Project	METROLINK - GENERAL ARRANGEMENT ALBERT COLLEGE PARK	Drawing Status	S0
Drawing Title	METROLINK - GENERAL ARRANGEMENT ALBERT COLLEGE PARK	Drawing N°	ML1-JAI-ARD-ROUT_XX-DR-Y-03098
Drawing N°	ML1-JAI-ARD-ROUT_XX-DR-Y-03098	Plan Drawing N°	ML-RO 304 1-2
Scales Original Size A1	1:500	Sheet	1 of 1

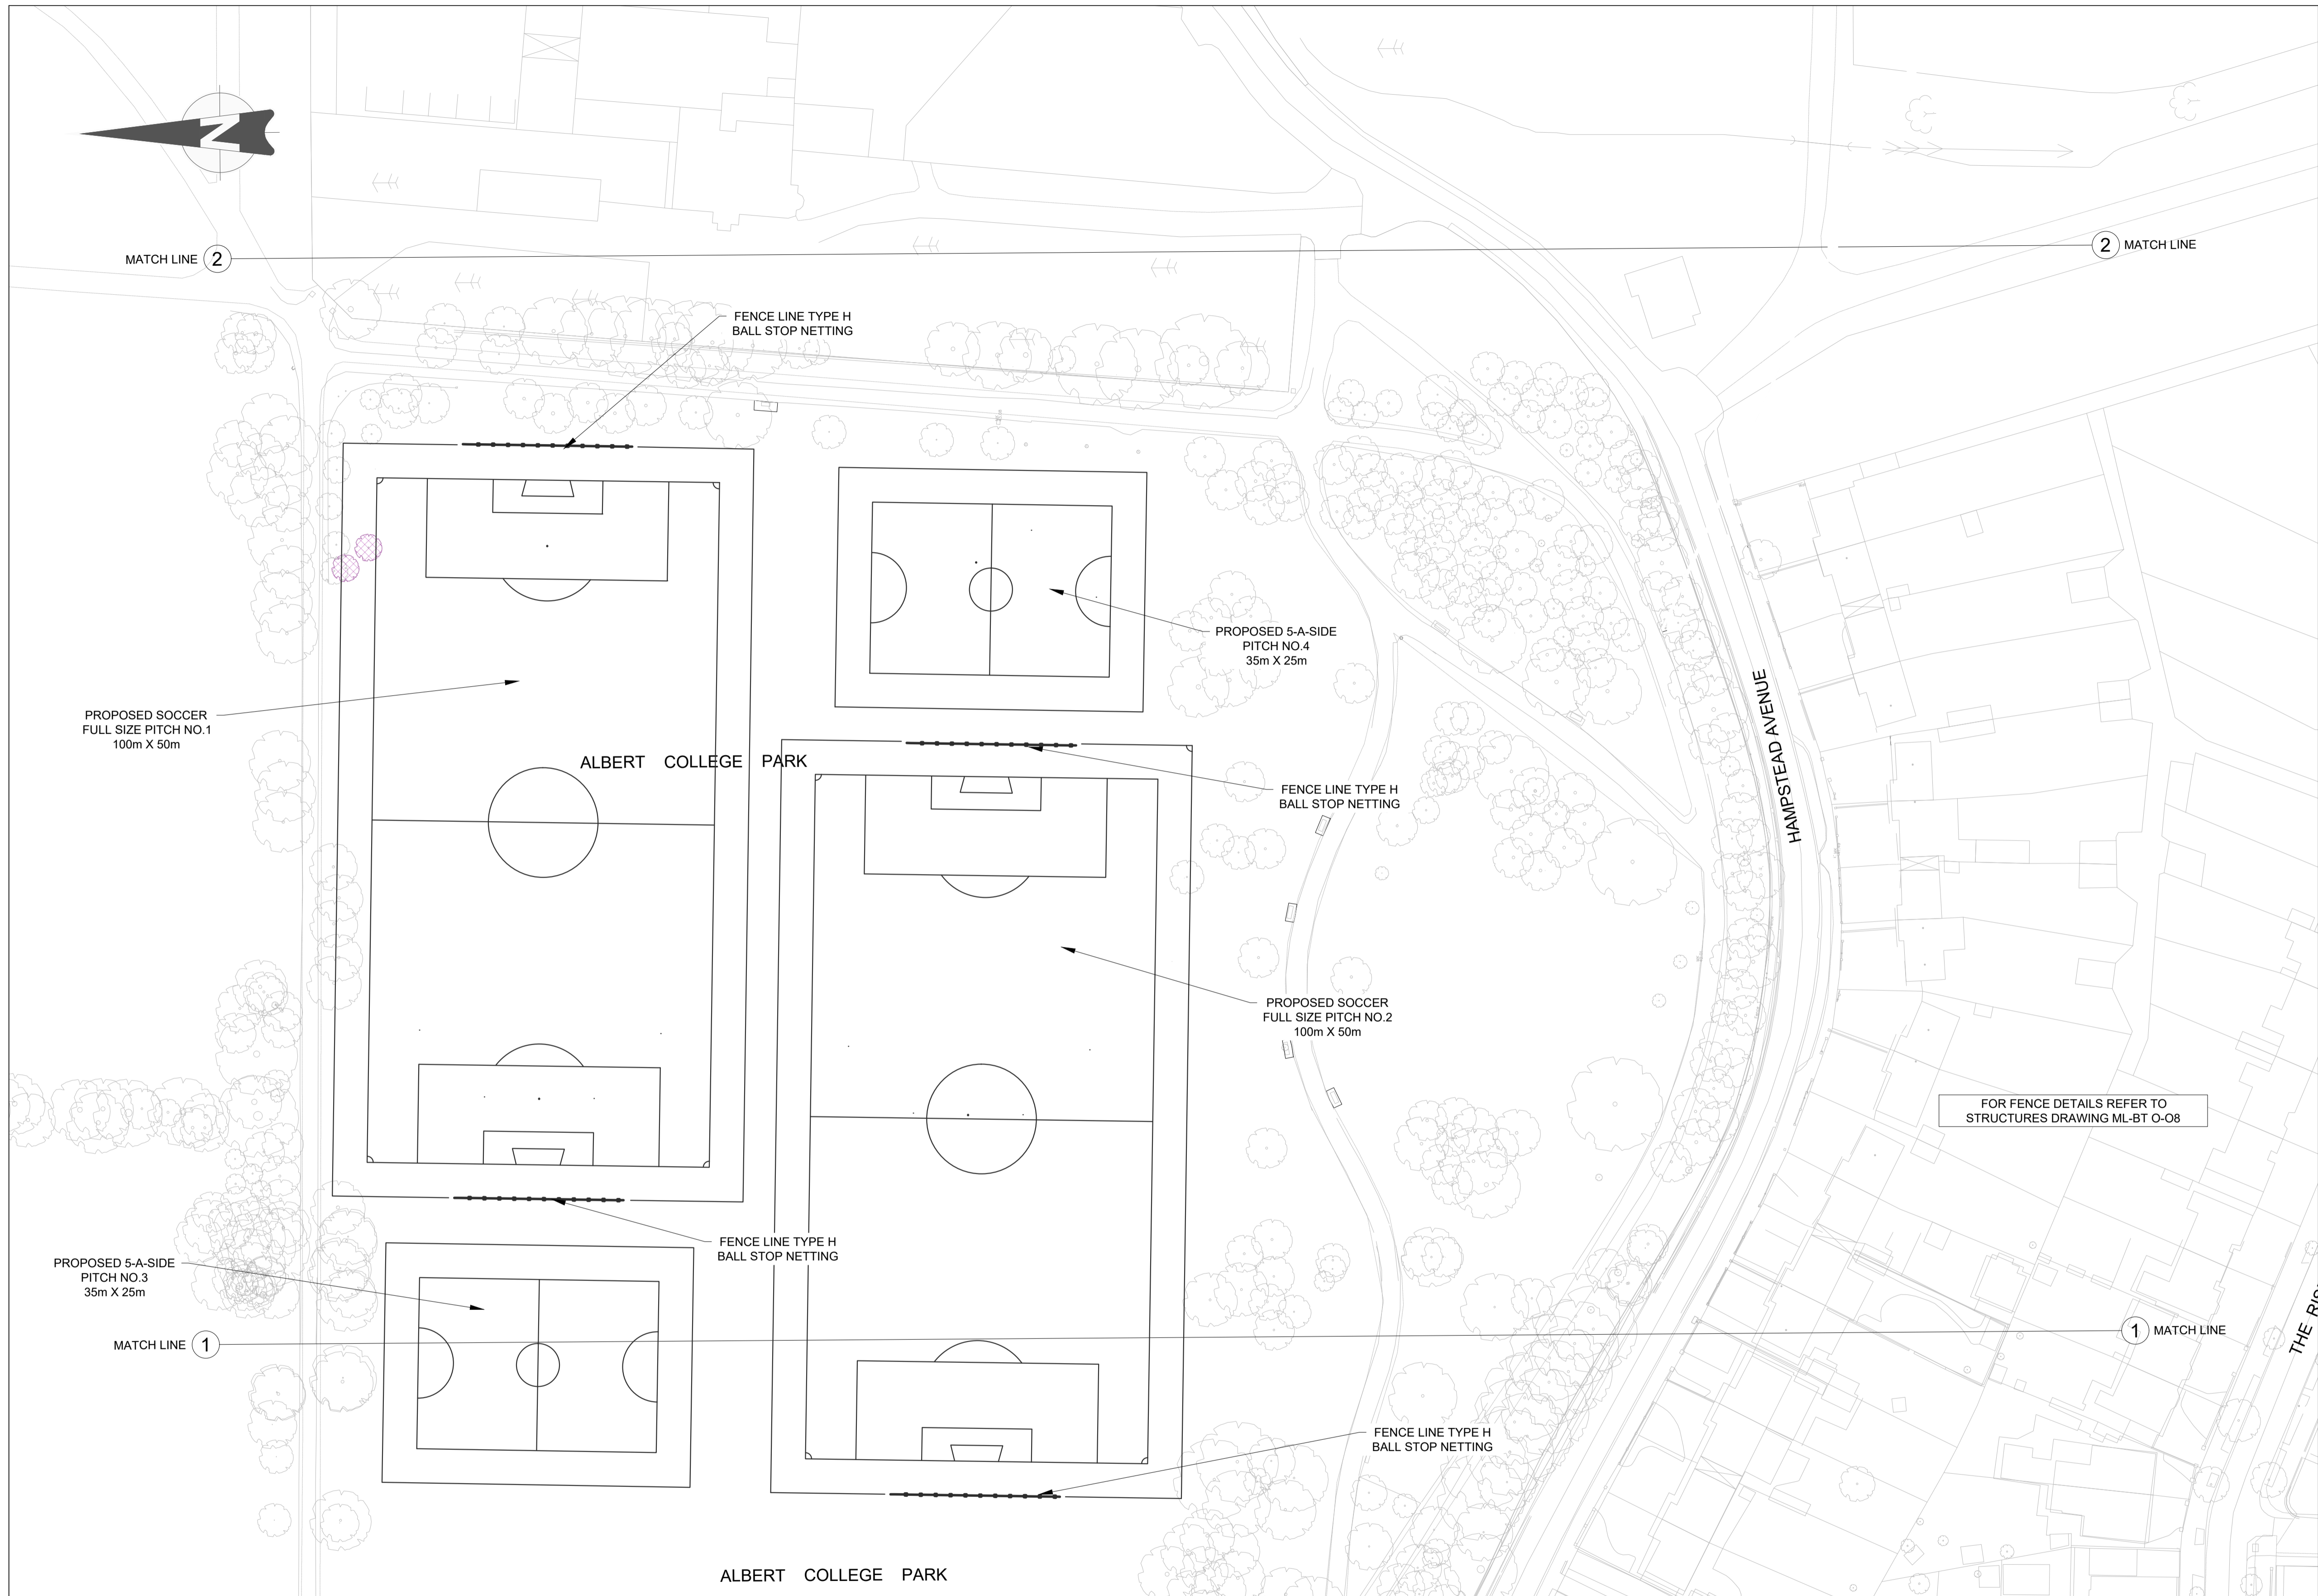
3	Observations of CLG Na Fianna	3	In addition to the site works on St Mobhí Road we wish to clarify that the construction works as outlined in the RPO will not disrupt the use of public facilities enjoyed by Na Fianna in the public park of Albert College.	<p>In order to ensure full functionality of the facility during the construction phase some of the pitches have been slightly relocated and realigned within the existing confines of Albert College Park to avoid any loss of amenity, for details see Railway Order Plans\Drawings, Alignment Details Book2 of 2, Dublin City Council, Plan Drawing Nos ML-RO 304 F-G and ML-RO 304 G-H. Works to the pitches will be carried out in agreement with the stakeholders concerned so as to minimise any disruption to sporting fixtures.</p>
4	Observations of CLG Na Fianna	3	In relation to the site of Collinstown Lane - we wish to ensure that all enabling works are conducted in such a manner as to minimise impact on the community based activities on this site.	<p>As identified in Chapter 11 (Population and Land Use), the pitches currently being used by CLG Na Fianna would be modified to accommodate the requirement to divert the existing open drain/river to the south of the grounds, which will result in the loss of land and impact one existing pitch. To mitigate this impact, this pitch will be rotated by 90°. The existing juvenile pitch will be relocated to the south west of the site and made larger.</p> <p>TII will continue to engage with DAA and CLG Na Fianna throughout the works so as to ensure that disruption to playing and training activities is minimised. It should be noted that the playing facilities will be enhanced through provision of additional pitch draining and flood lighting.</p>
